From: Steven Shaw 
Sent: 16 August 2018 16:58
To: Anita Gardner
Cc: Andy Marshall; 
Subject: CM/16/18/PL Dementia Care Centre, rear Bairds Farm Shop, Climping, Littlehampton

Further to my comments on the above application I have now received the following documentation:

DRAWING TITLE
Highway Improvements

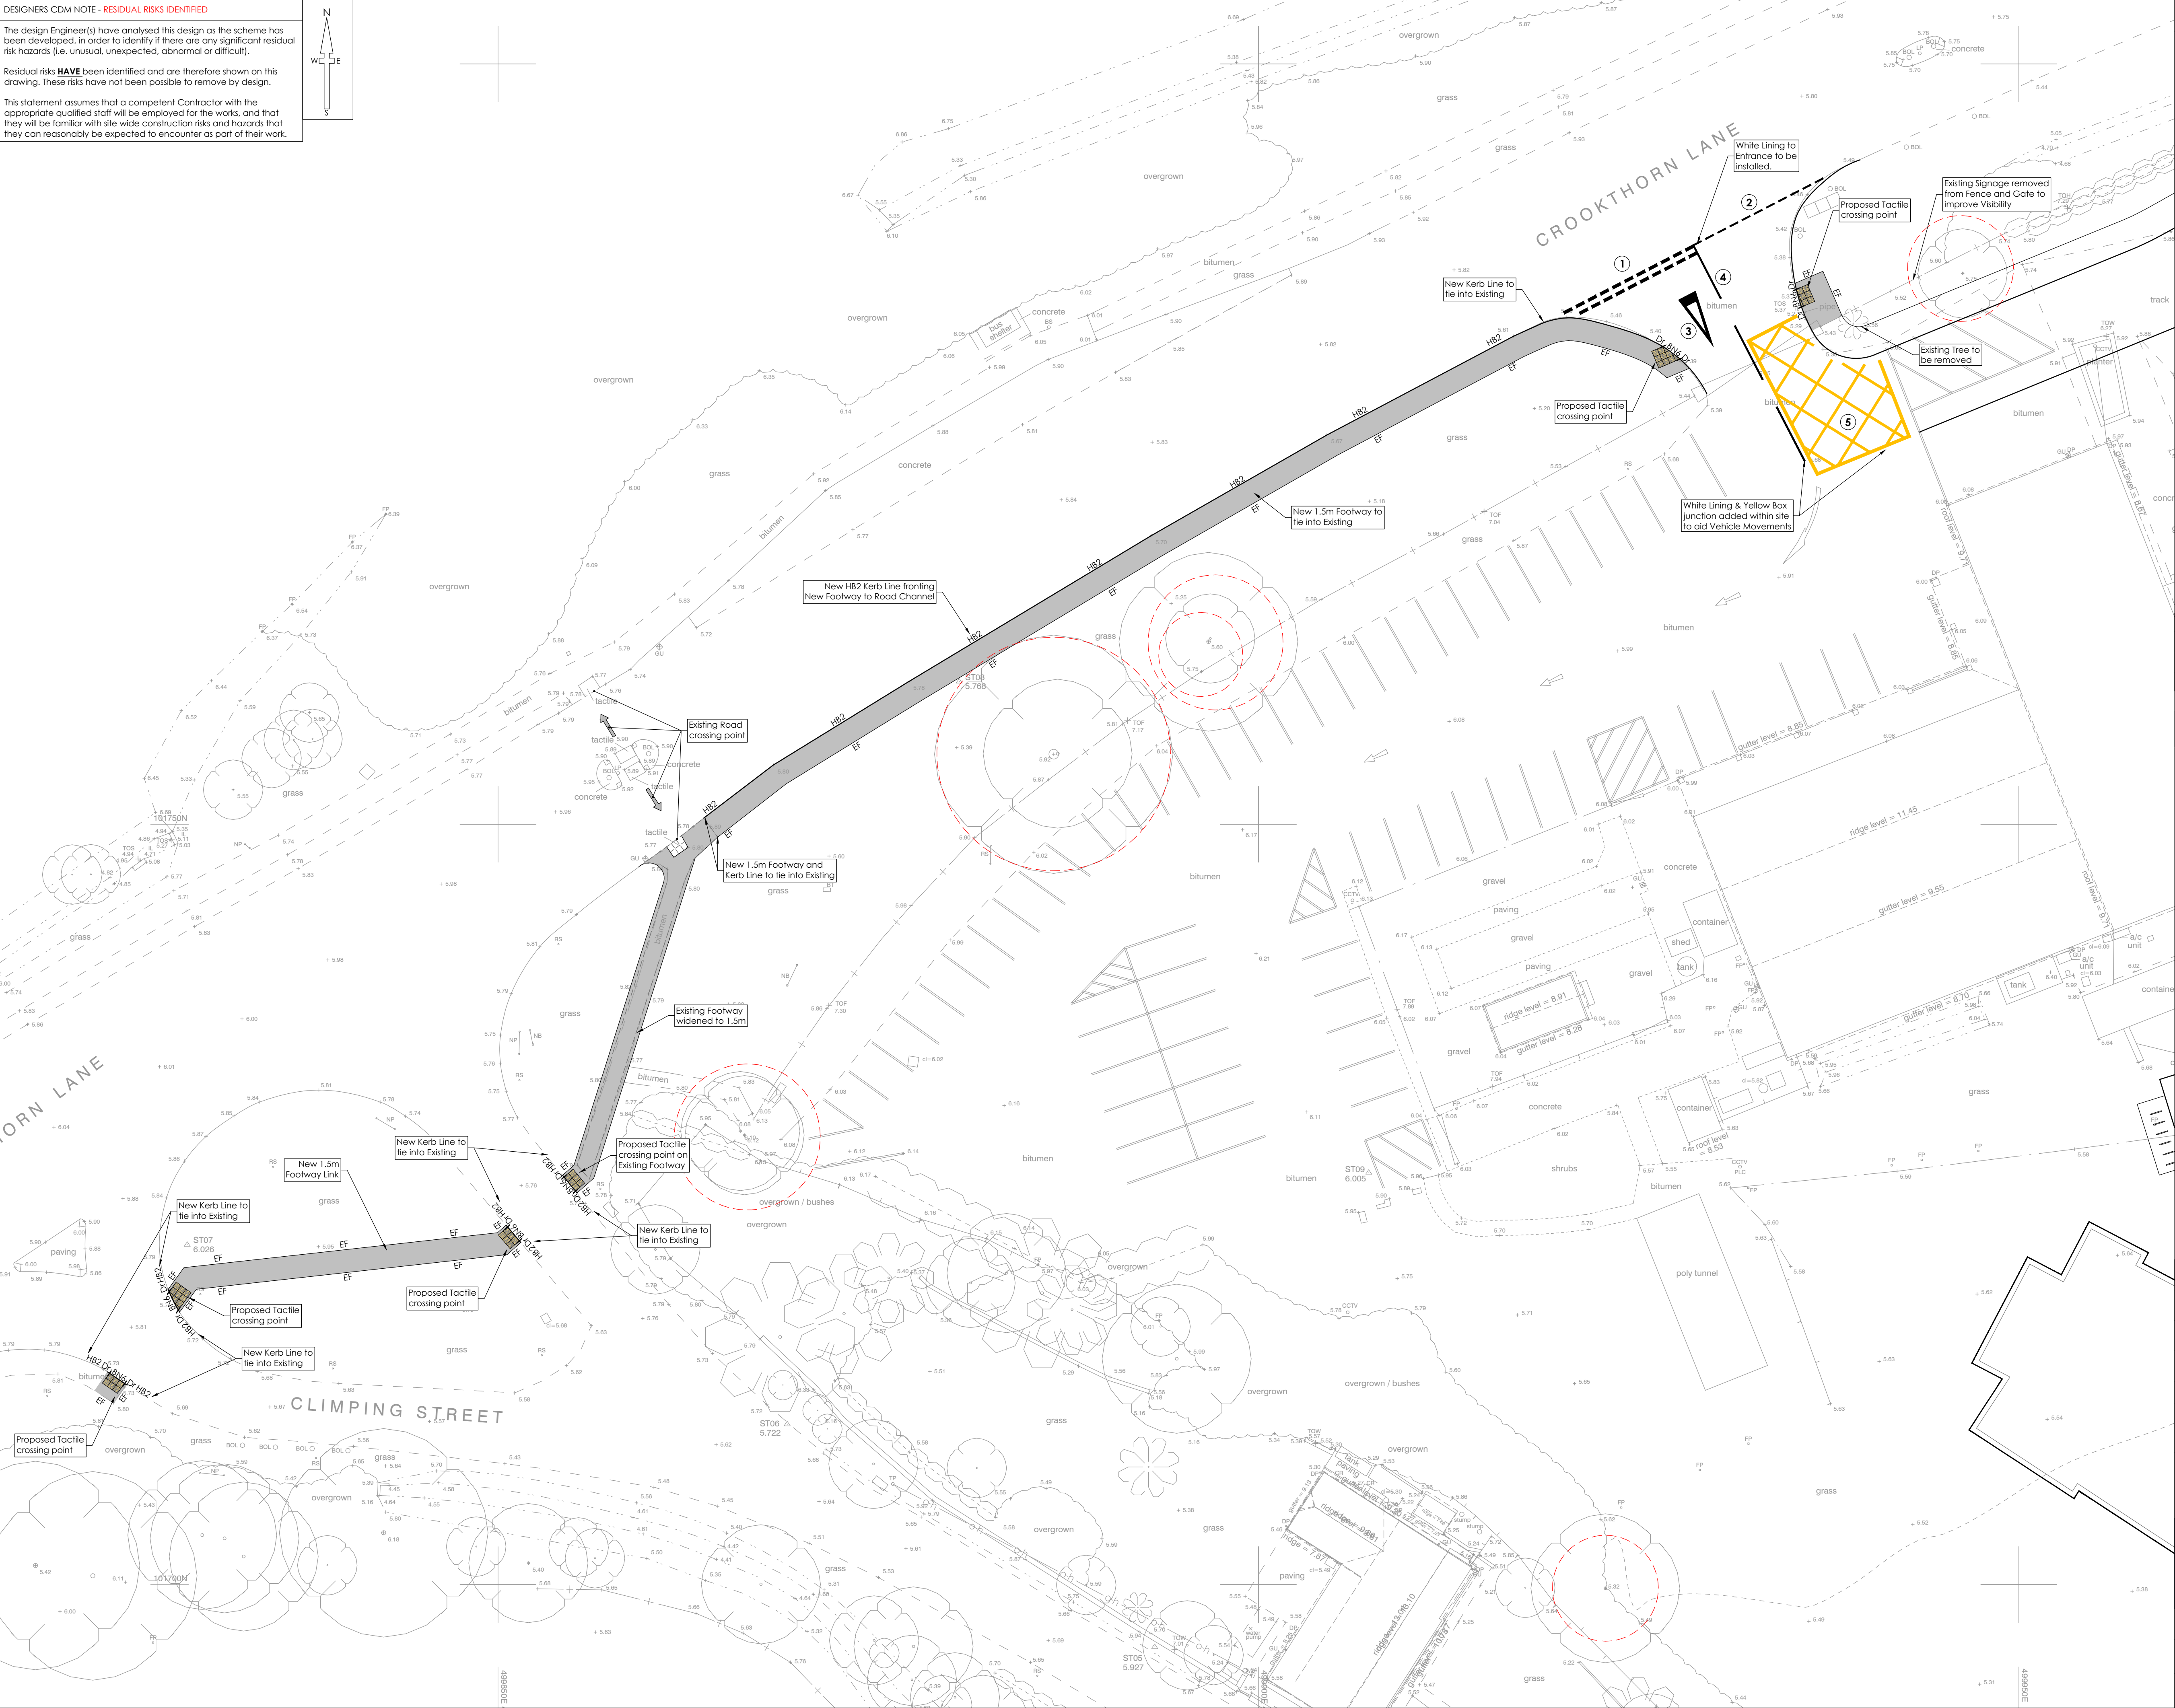
- Problems 8.1 – 8.4 have been addressed by the designer.
 - Problem 8.5 states, Description: A new footway is detailed from the development out onto the A259. There is no central pedestrian refuge island on the A259 to enable pedestrians to cross the road only a central island. This island needs to be changed to a pedestrian refuge and appropriate dropped kerb /tactile paving crossing point provided

Type of conflict/collision: Pedestrians having to cross full height kerbs and stand on central hatching to cross road

Recommendation: Provide appropriate refuge island and crossing point at end of new footway

Therefore the Highway Authority would look for the applicant to address this issue by providing appropriate refuge island and footway to link into the proposed footway adjacent to the site access to provide a continuous footway. A revised drawing should be provided which incorporates these additional highway works and suitably addresses the concern raised by the RSA.

- **Shared Pedestrian/Cycle route** – WSCC Walking & Cycling Officer has requested that the proposed 1.5m pedestrian route to the south of the A259 is amended to be a 3m shared path instead. Given the recent improvements and implementation of cycleway on the northern side of the A259 this will help cyclists who are travelling to the site travel the majority of their route on bike. Therefore the route could be moved away from being directly adjacent to the A259 and be 3m wide and signed as a shared pedestrian/cycle route.

Once this improvement and the aforementioned pedestrian refuge works are drawn up onto a revised highway works plan it should be shared with the safety auditors for any additional comments.
